COMMENT RESPONSES 8-3-22

Flying Horse North SKP

HR Green

SKP223

FLYING HORSE NORTH SKETCH PLAN
SKETCH PLAN DRAWING

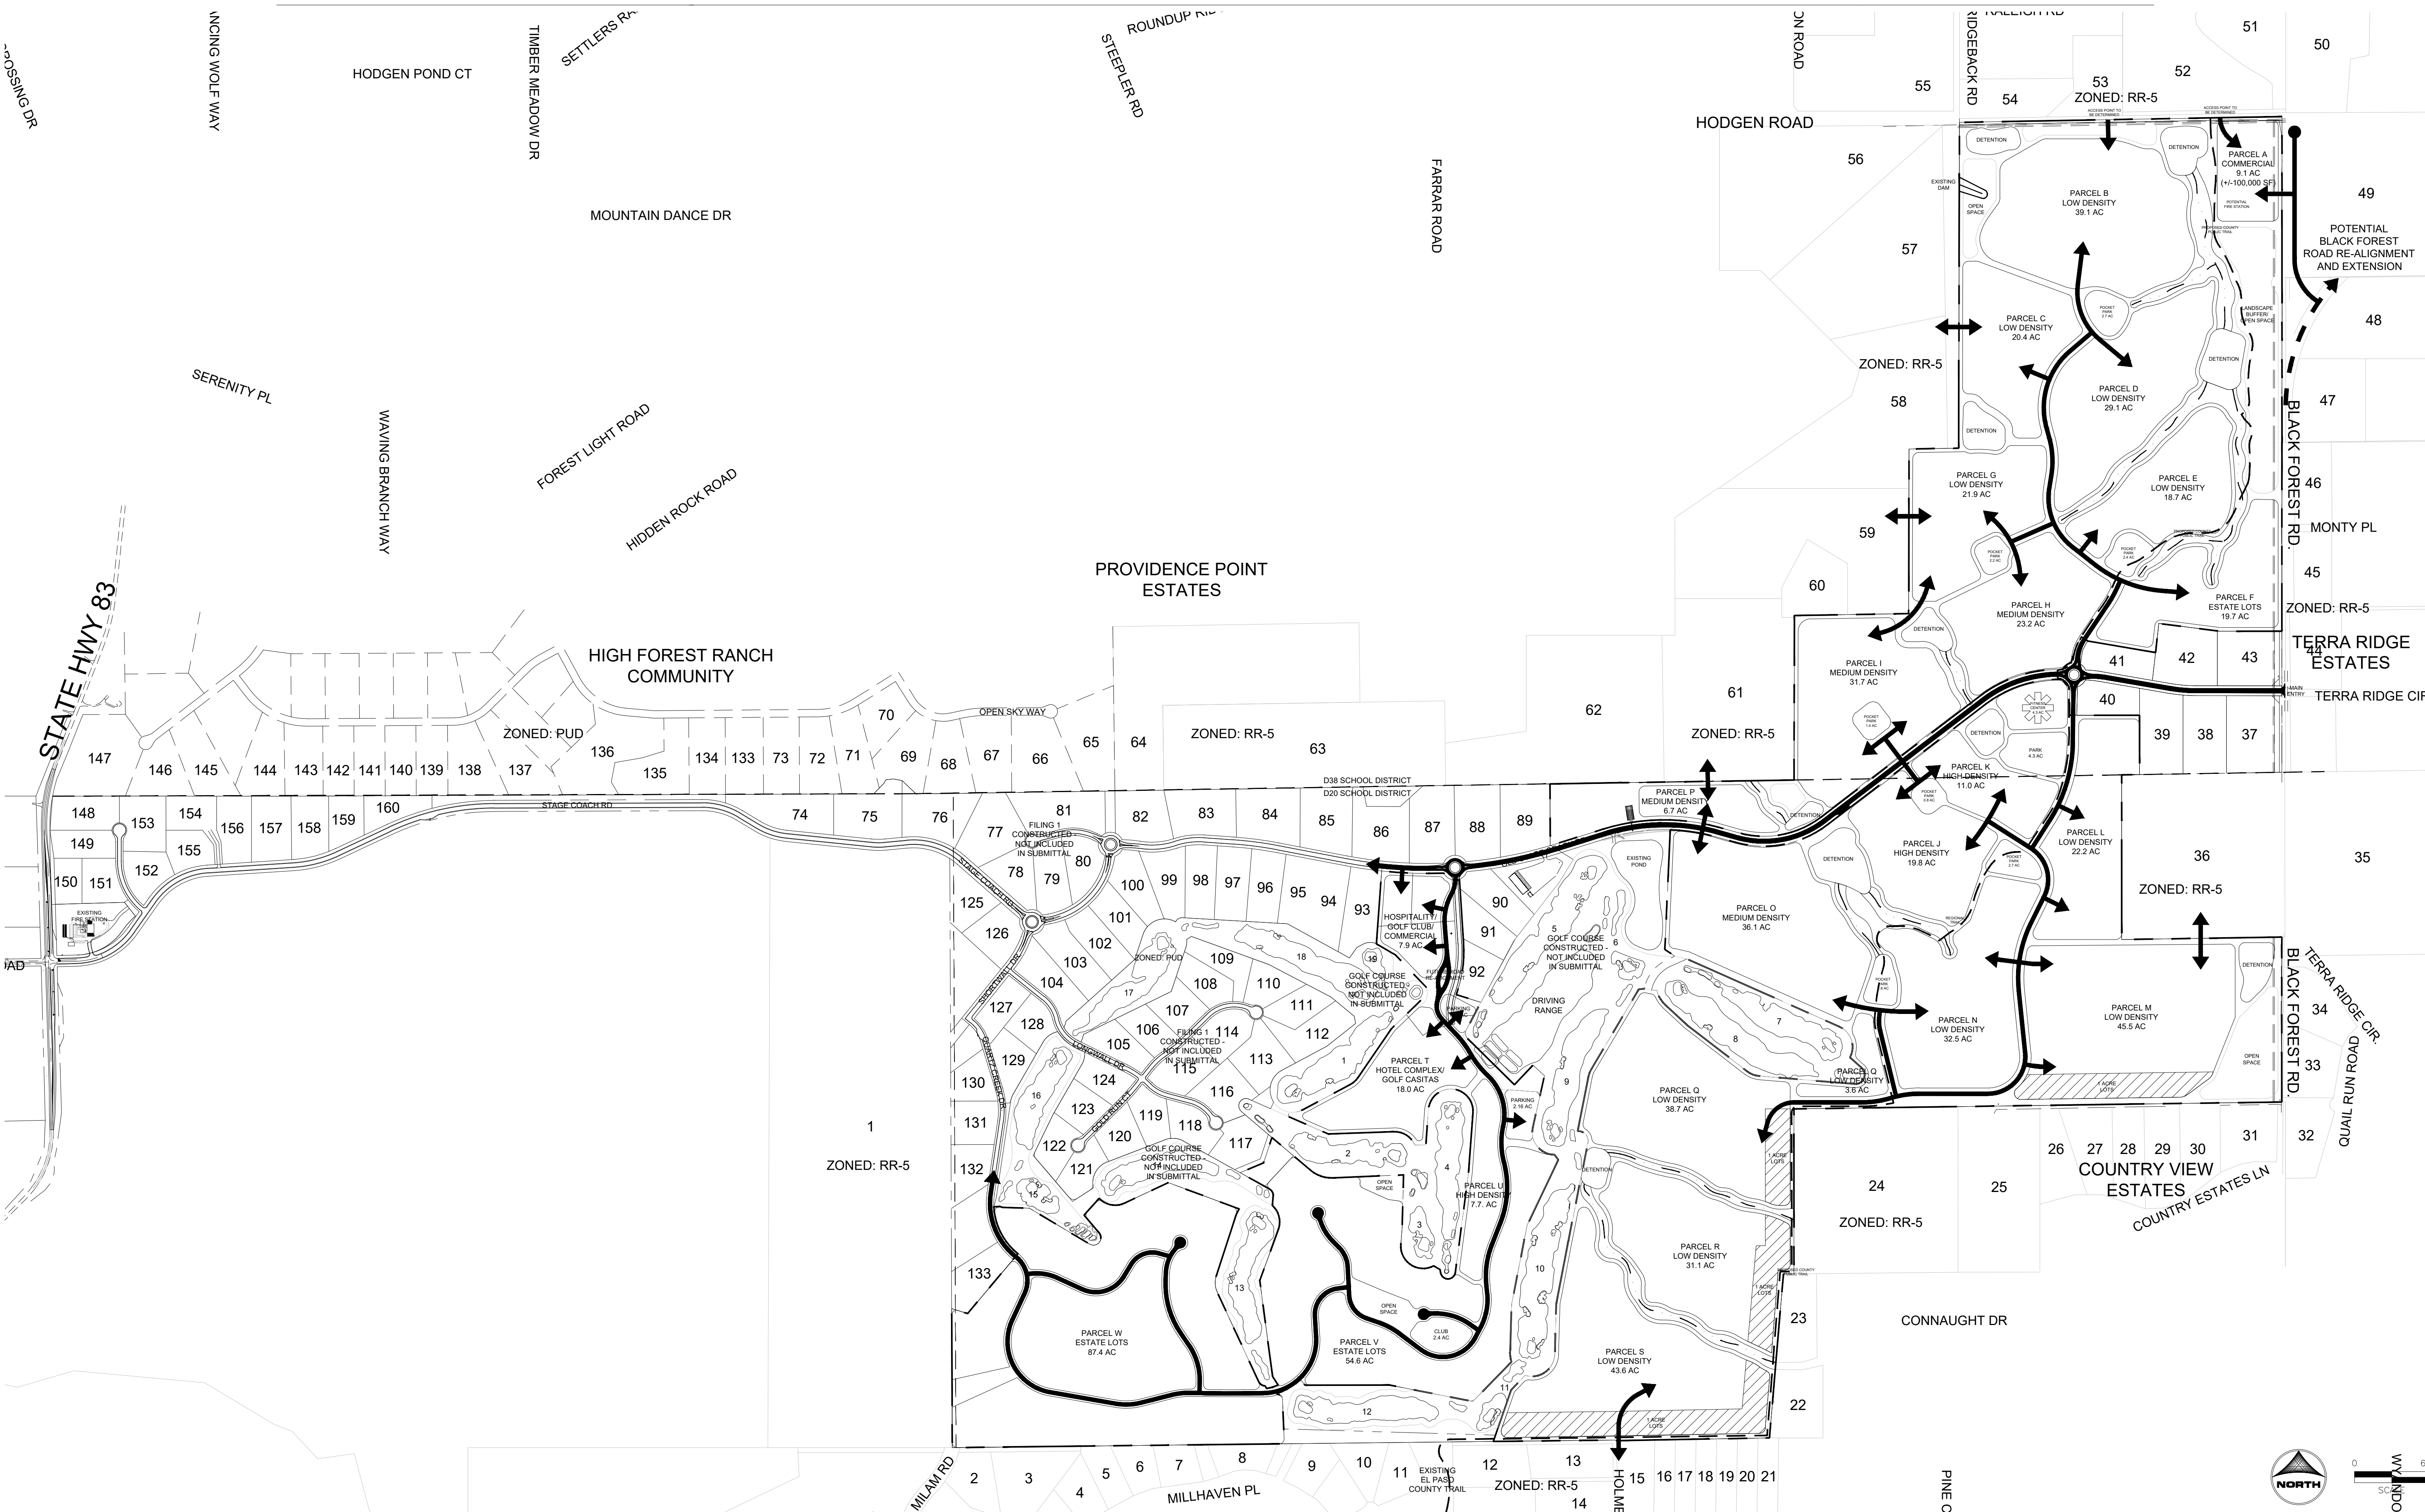
PCD Project Manager	Impact ID Redlines	4/18/2022 5:16:08 PM
PCD Project Manager	LOI Redlines	4/18/2022 5:15:00 PM
PCD Project Manager	MDDP Redlines	4/18/2022 5:13:41 PM
PCD Project Manager	Soils & Geology Redlines	4/18/2022 4:55:03 PM
PCD Project Manager	The subdivision summary sheet includes an acreage of 1,459 whereas all other application documents include 912.5 acres. CHANGE ACREAGE TO THE CORRECT NUMBER	4/18/2022 4:53:34 PM
Black Forest Land Use Committee		4/18/2022 8:56:20 AM
EPC Stormwater Review	Review 1: EPC Stormwater comments have been provided (in orange text boxes) on the following uploaded documents: - MDDP (to be uploaded by PM with PCD comments) Reviewed by: Christina Prete, P.E. Stormwater Engineer III christinaprete@elpasoco.com	4/16/2022 1:47:58 PM MDDP HAS BEEN REVISED ACCORDINGLY
